COUNTY COUNCIL'S RESPONSE TO CONSULTATION ON THE FOLLOWING DEVELOPMENT PROPOSAL

Application No: 18/00825/HYBRID-5

Location: Heyford Park Camp Road Upper Heyford

Transport Development Control

SCALE	1:200 @ A0	DATE	JULY 2020
DRAWN	NK	CHK	JGF
DRAWING NO.	16871-SK380	REV	B
TITLE	CAMP ROAD UPPER HEYFORD		
DETAILS	POSSIBLE FOOTPATH SECTION 278 WORKS ON CAMP ROAD EAST

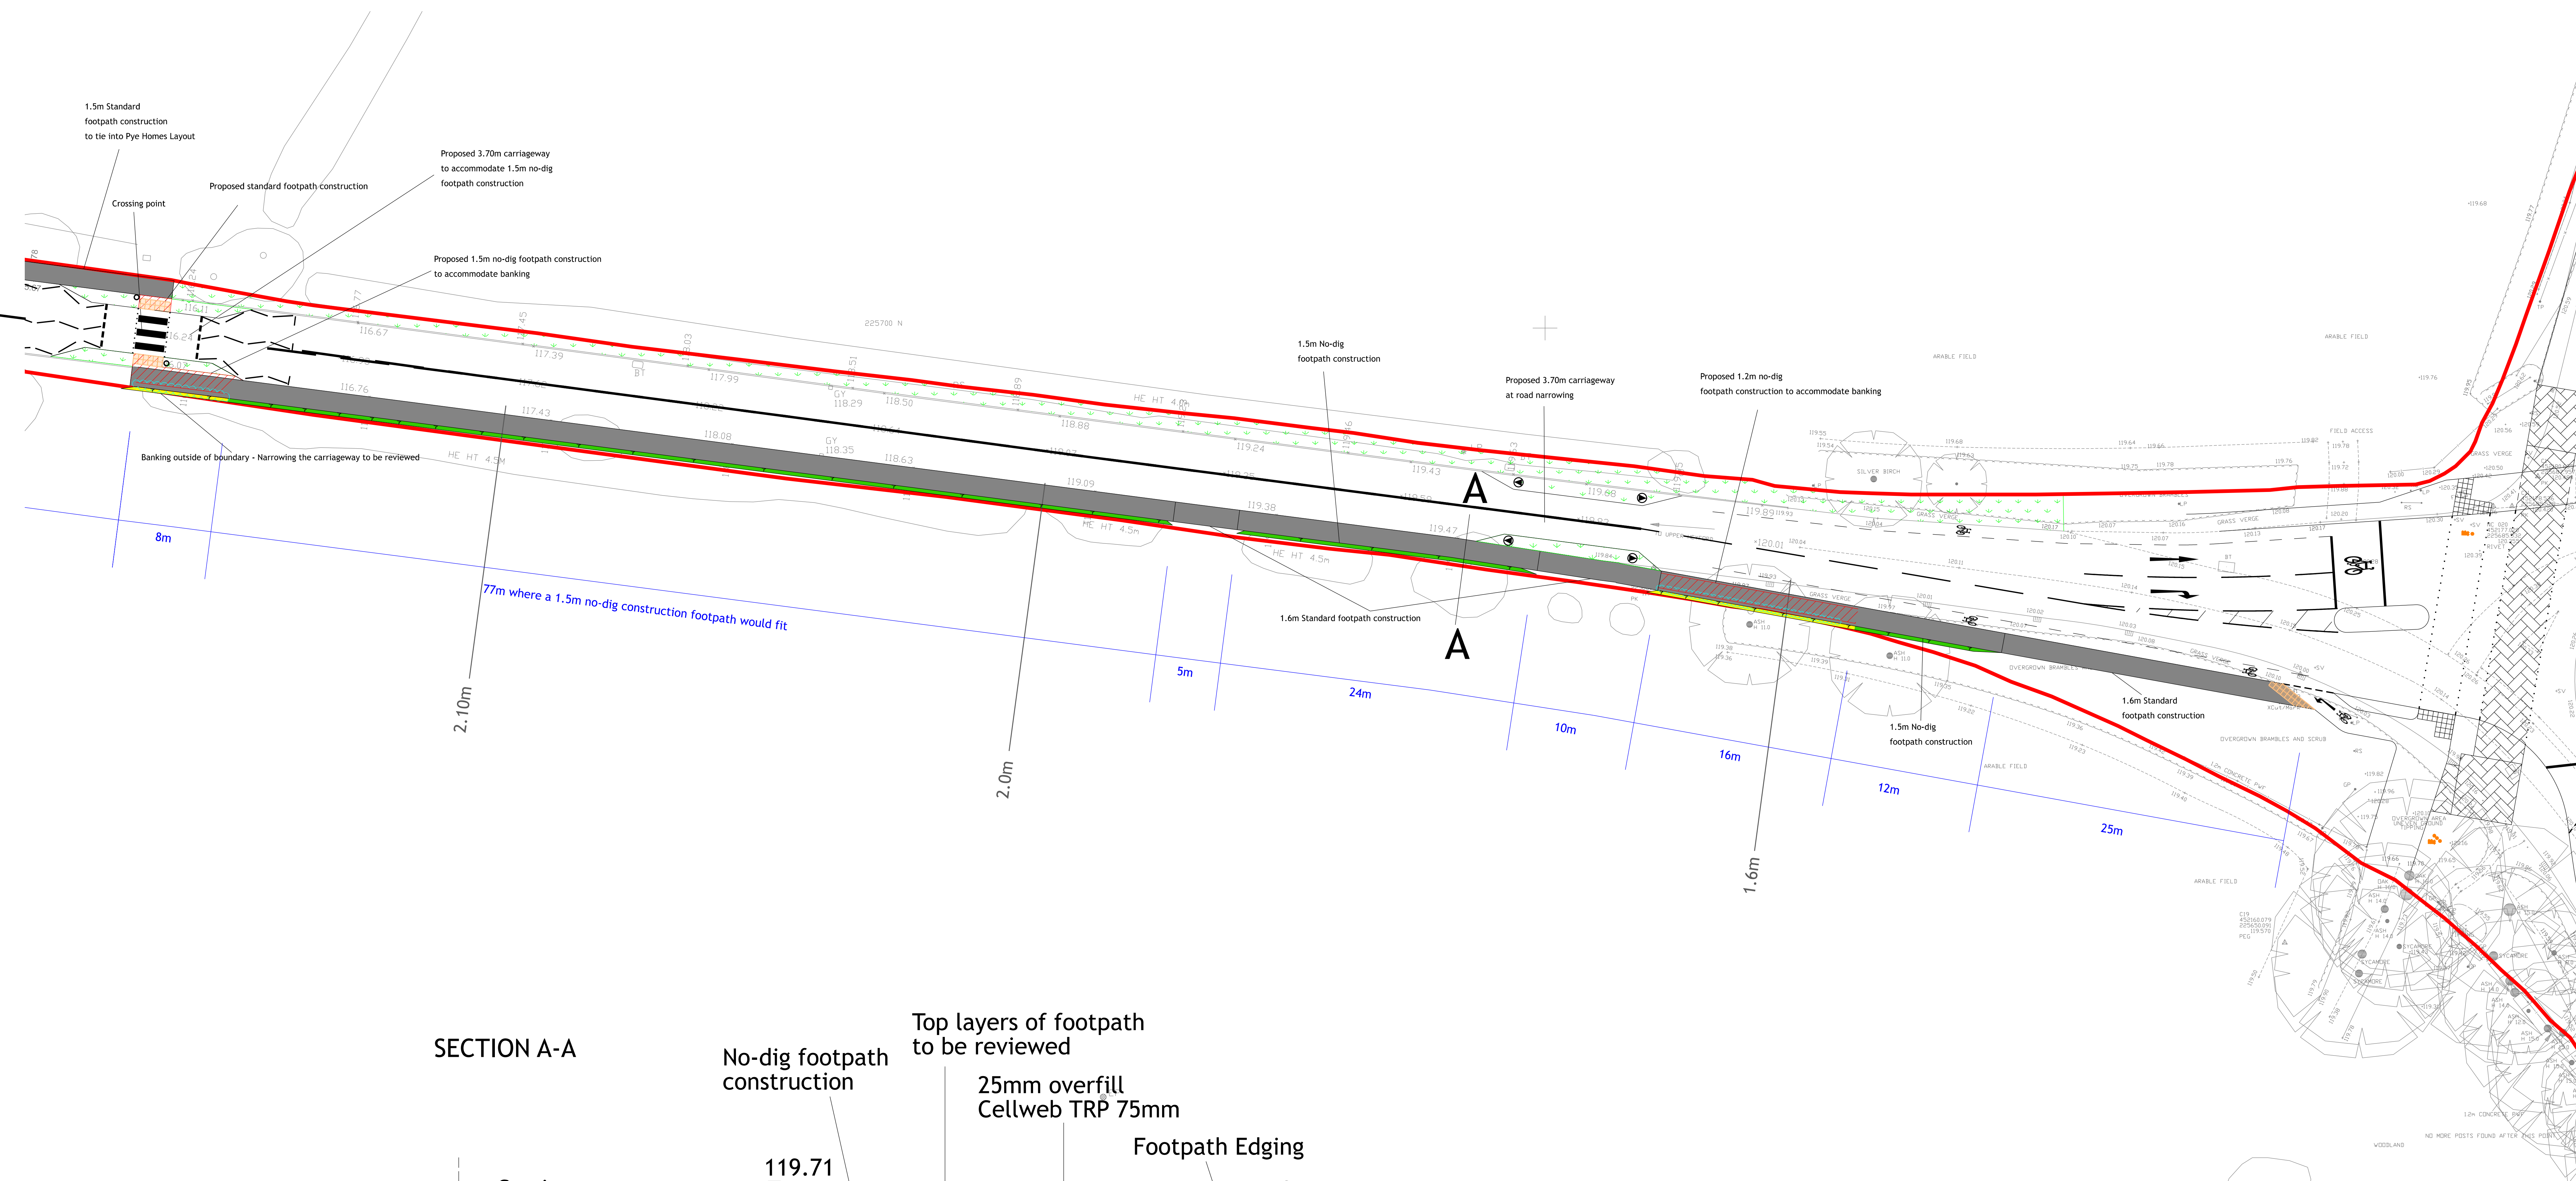
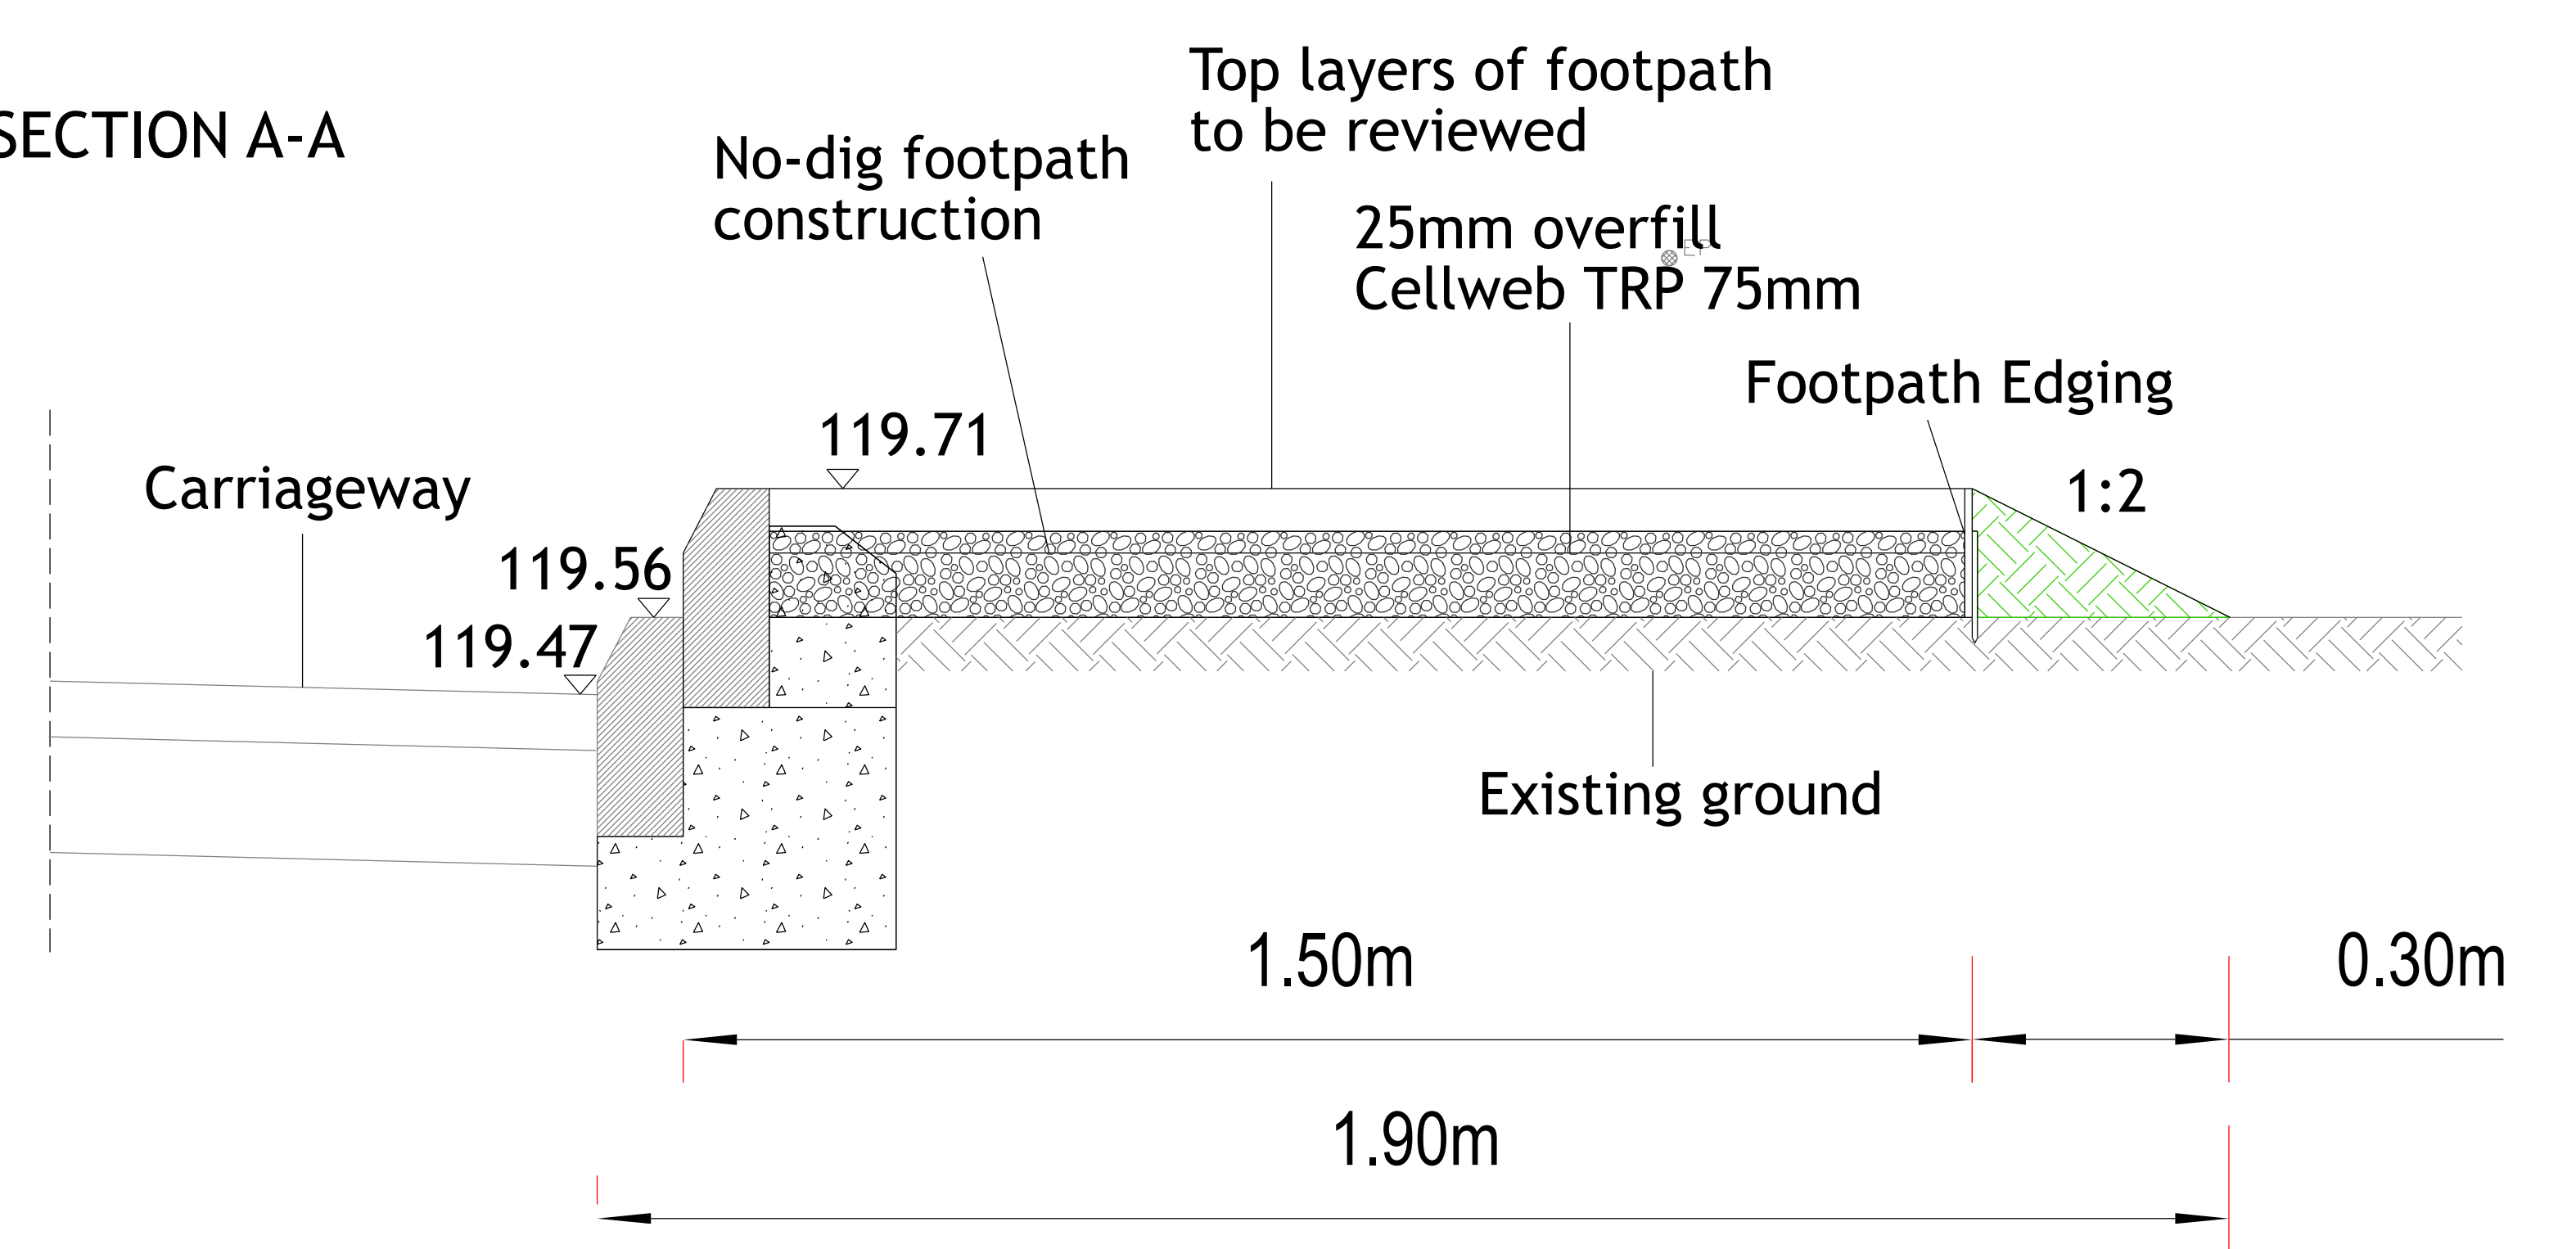
- Public rights of way: We welcome the revised parameter plan showing Aves Ditch inside the existing fence around the southern bomb store
- Camp Road works: We have received revised plans 16871-SK381 Rev B and 16871-SK380 Rev B, which show a continuous footway linking existing provision with the new signalised junction at Chilgrove Drive. This is

acceptable in principle subject to technical approval, and the footway will need to be completed once Chilgrove Drive is open as an access to the employment area. Part of it may be completed as required highway works for the 'Pye Homes' site off Camp Road if that development comes first.
